**Darlington Public School Redevelopment (SSD-9914)
Request for Additional Information**

I refer to the Response to Submissions (RtS) for the Darlington Public School Redevelopment (SSD-9914). After careful consideration, the Department is requesting that you provide additional information that effectively addresses the issues identified below.

title
Landscape Plans
Landscape Ground Plane Plan

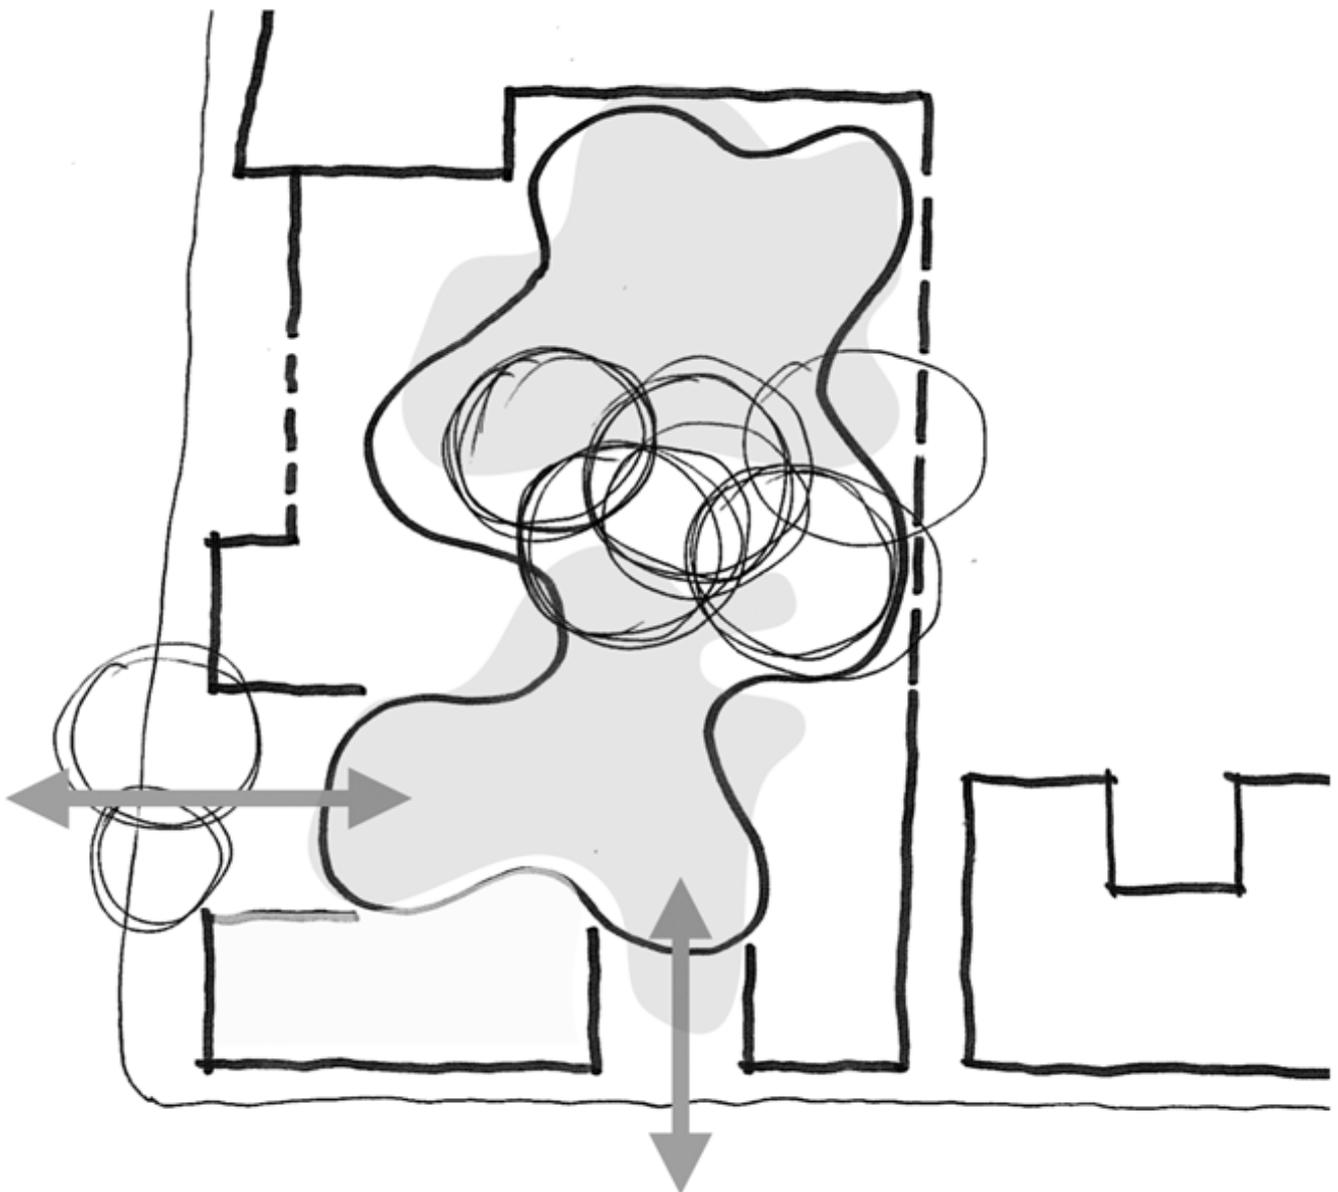
Tree retention should be maximised, particularly where tree removal is not required for building construction. Landscaping should be designed to enable tree retention wherever possible.

The amended Indicative Planting Palette included in the RtS does not include the proposed numbers of each species to be planted. Please provide an updated planting schedule that includes the proposed numbers of each tree species.
